Our Ref: A/85/18/RES
Your Ref:

Application for Approval of Reserved Matters Following Outline Approval

Development Approval of reserved matters for appearance, landscaping, layout & scale following outline consent A/131/16/OUT for 9 No one & a half storey houses with garaging, including 3 No. affordable housing units.

Location Land between New Place Bungalow and Arundel Road Angmering

ELEVATIONS: combined
UNITS: 2 + 3

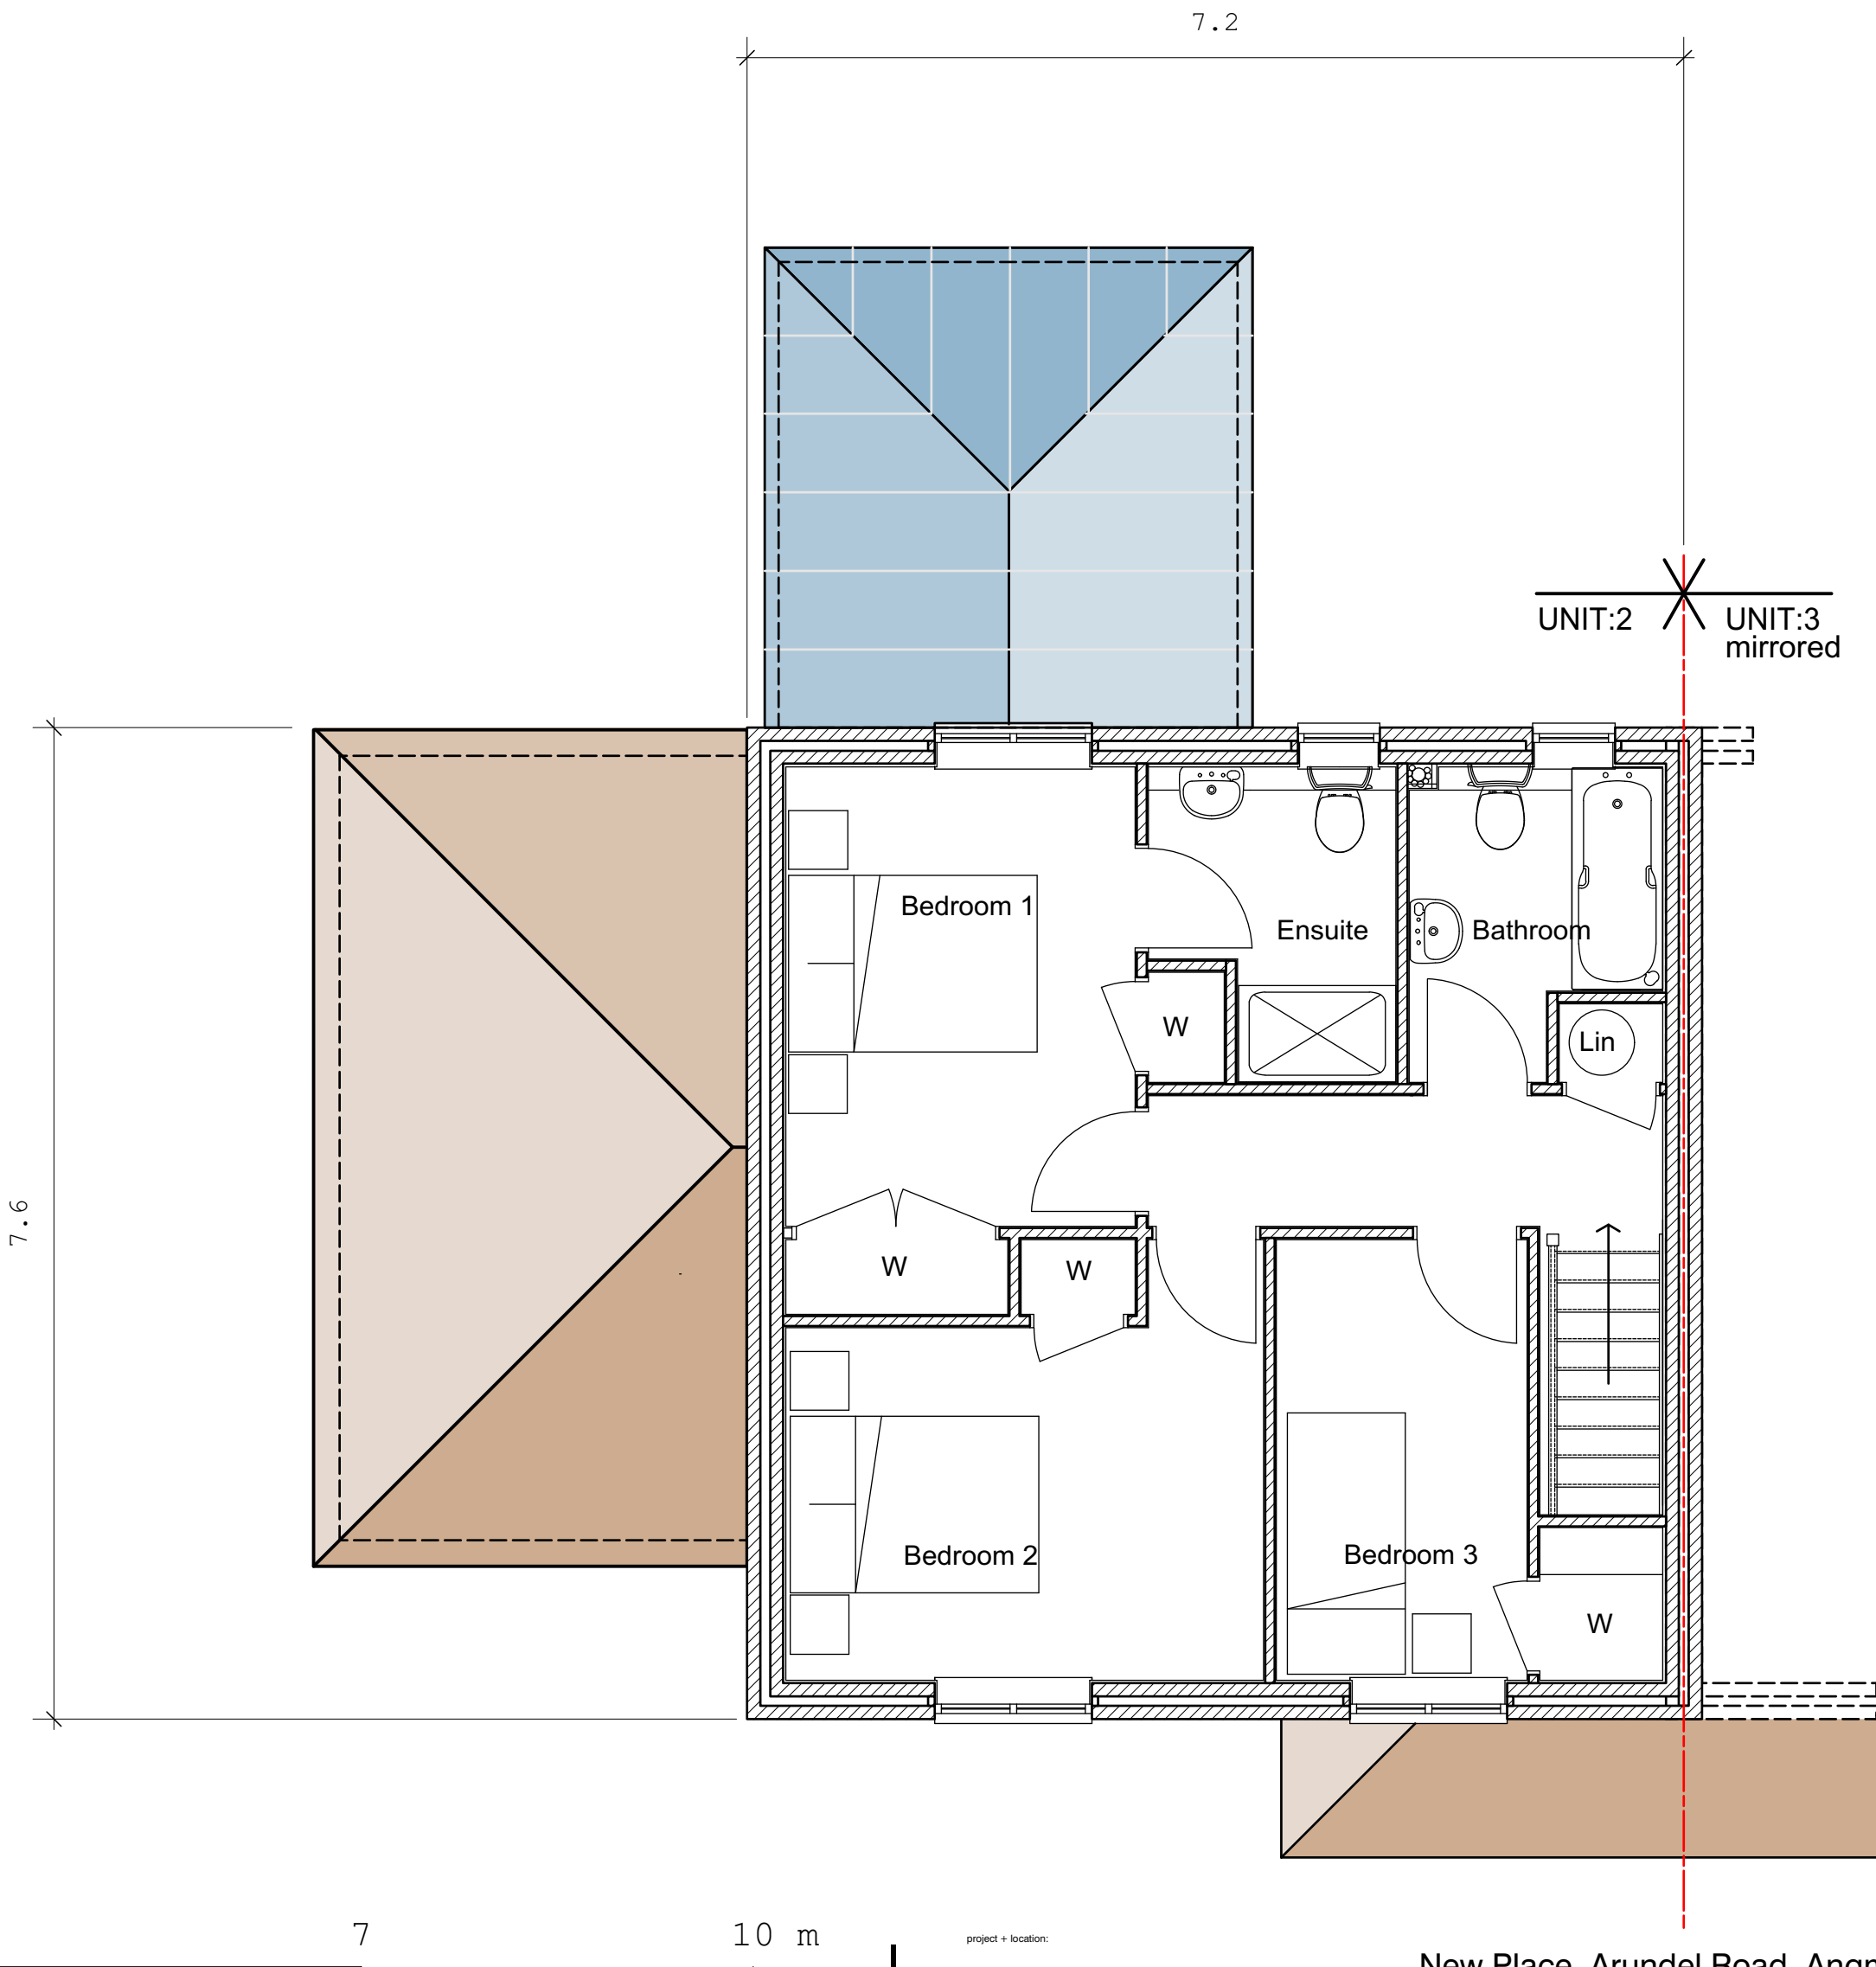
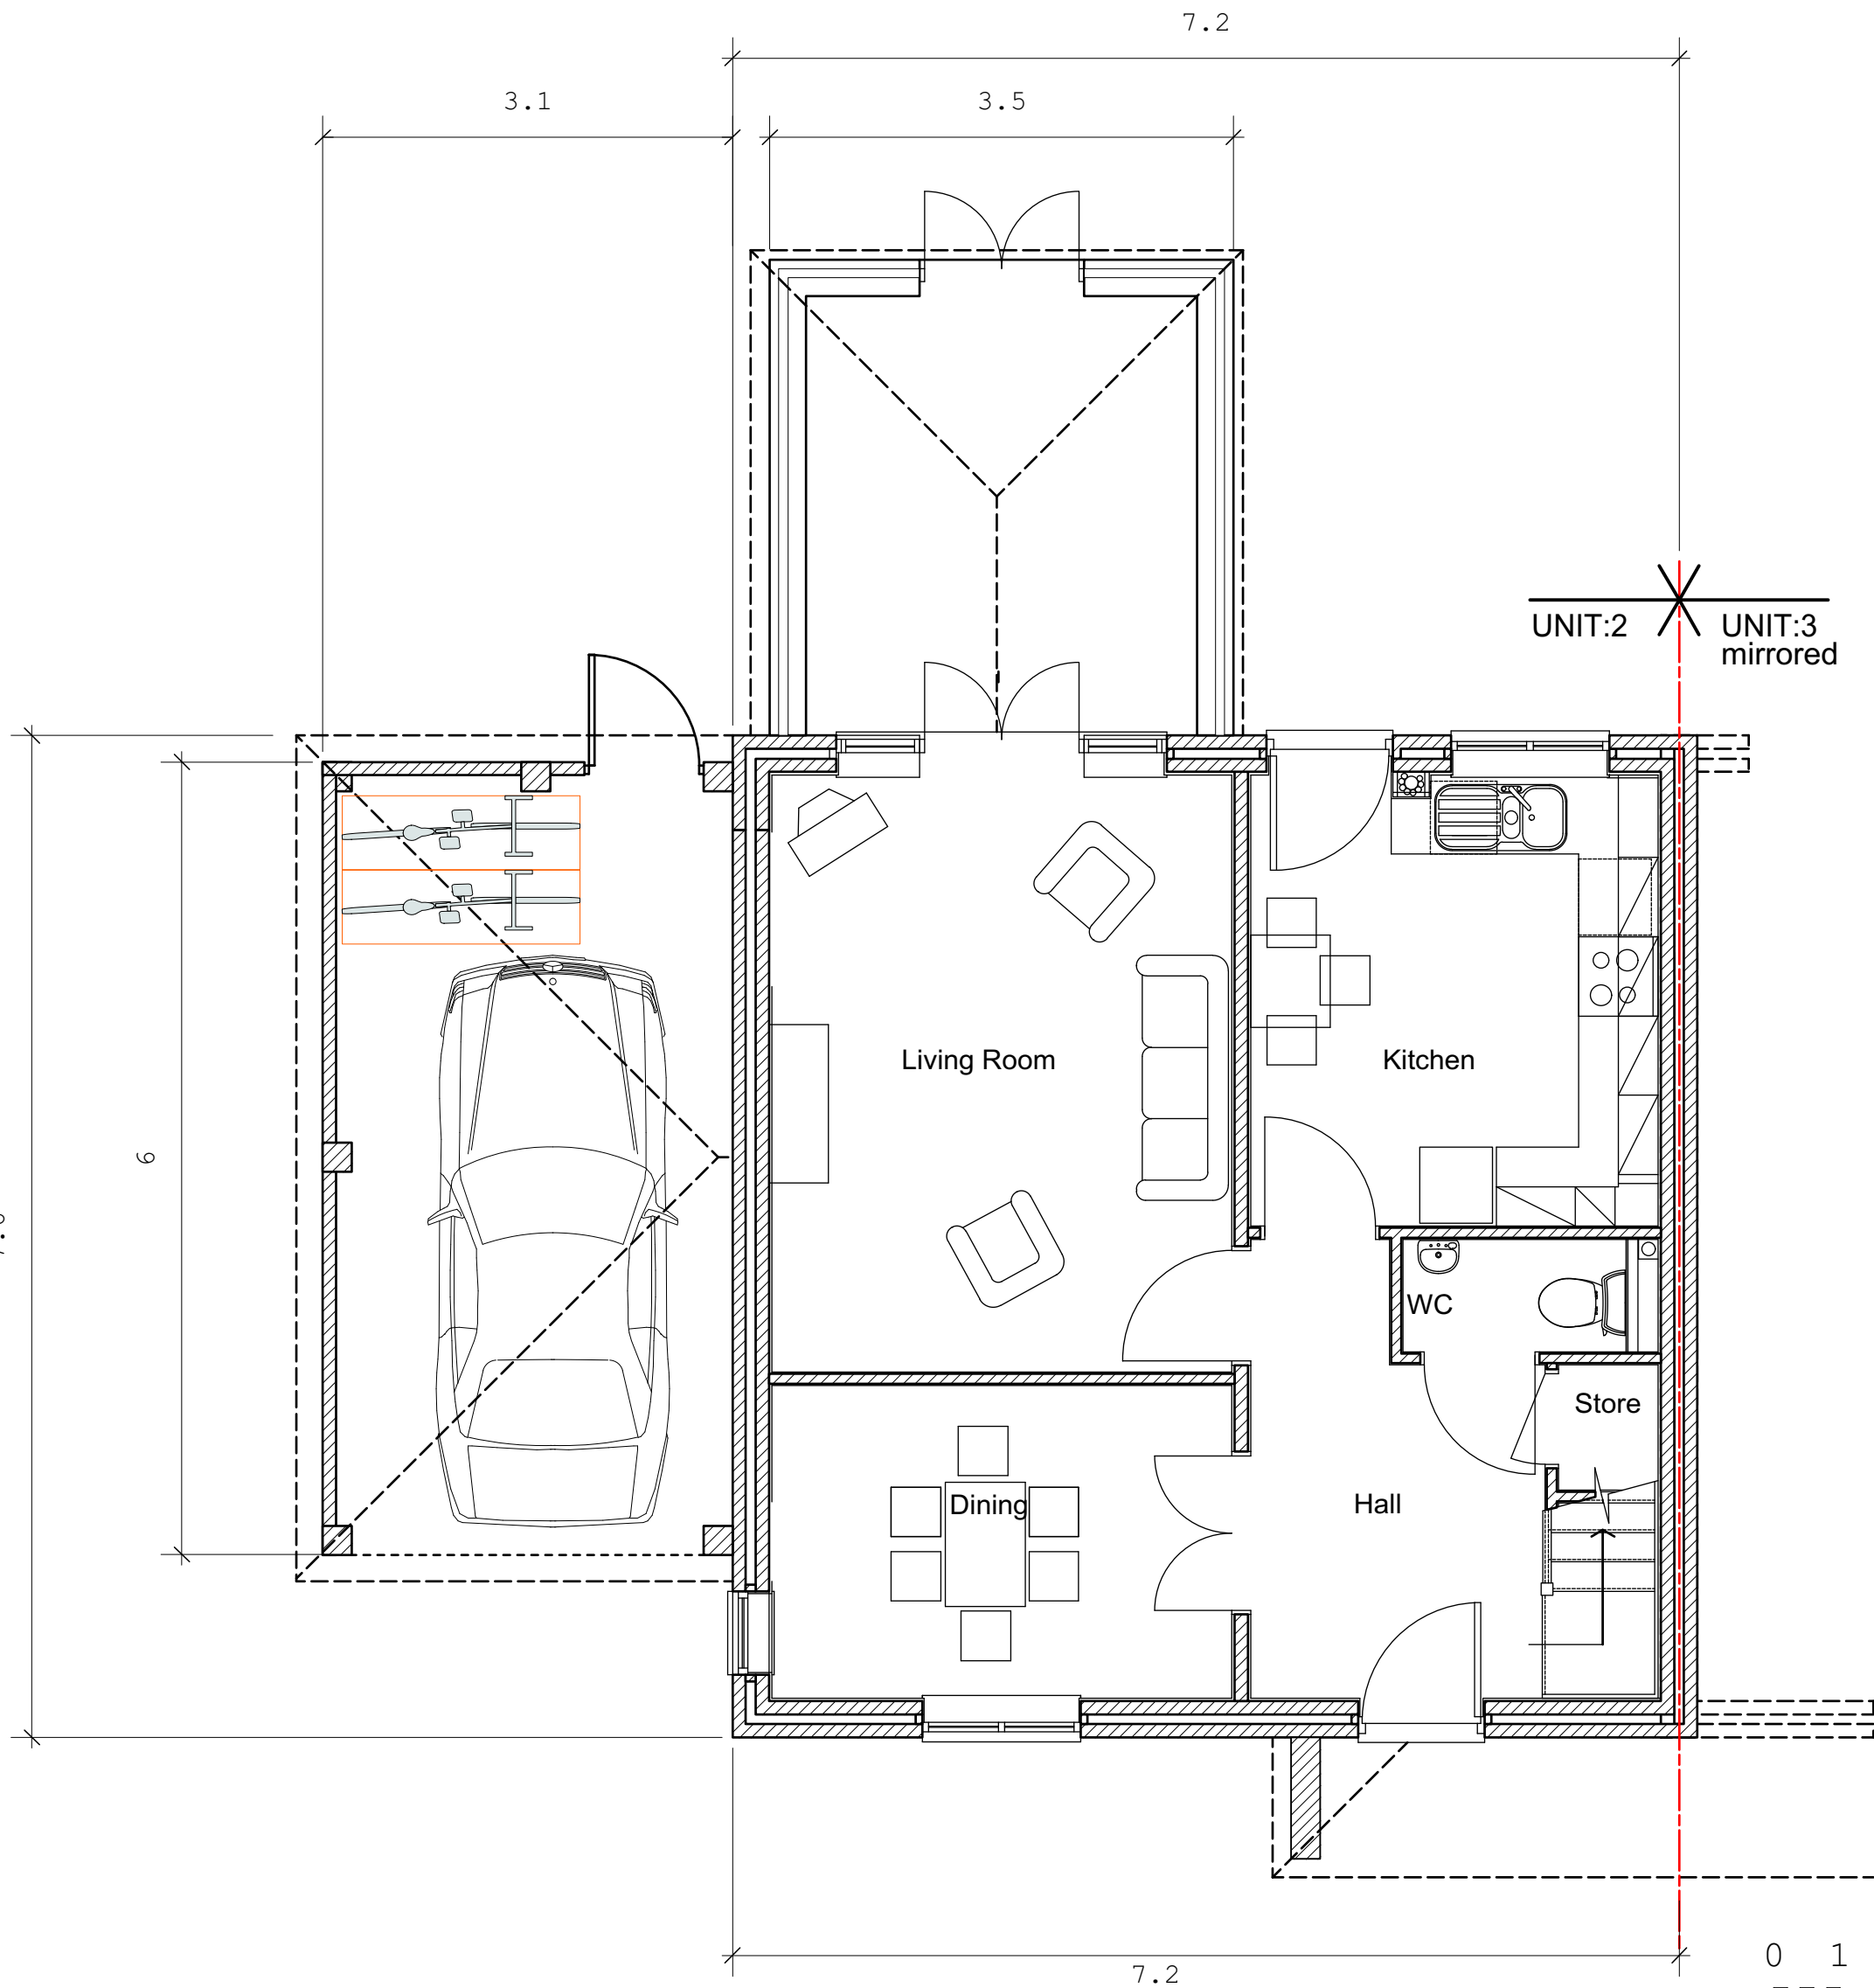
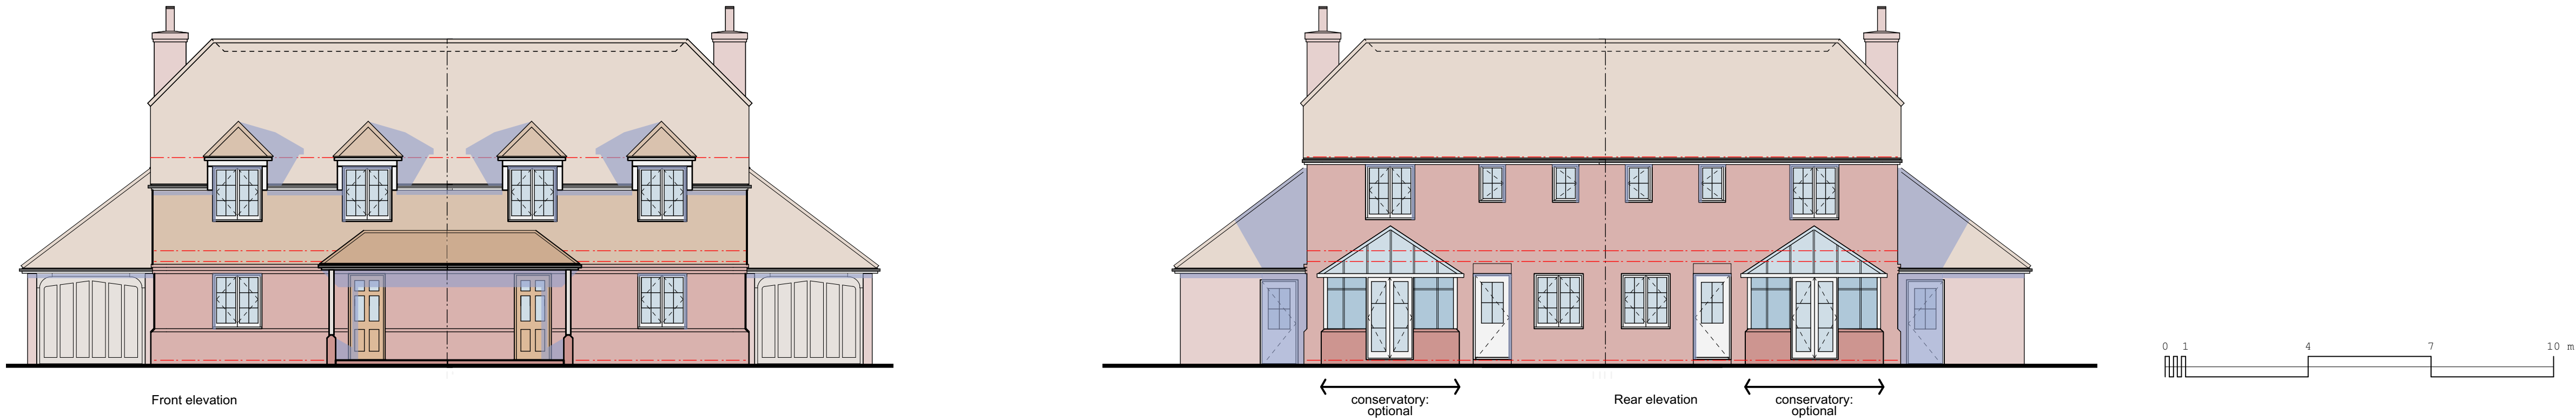
The plans, Unit B & C, rear elevation and ground floor plans do not accord. Please amend accordingly.
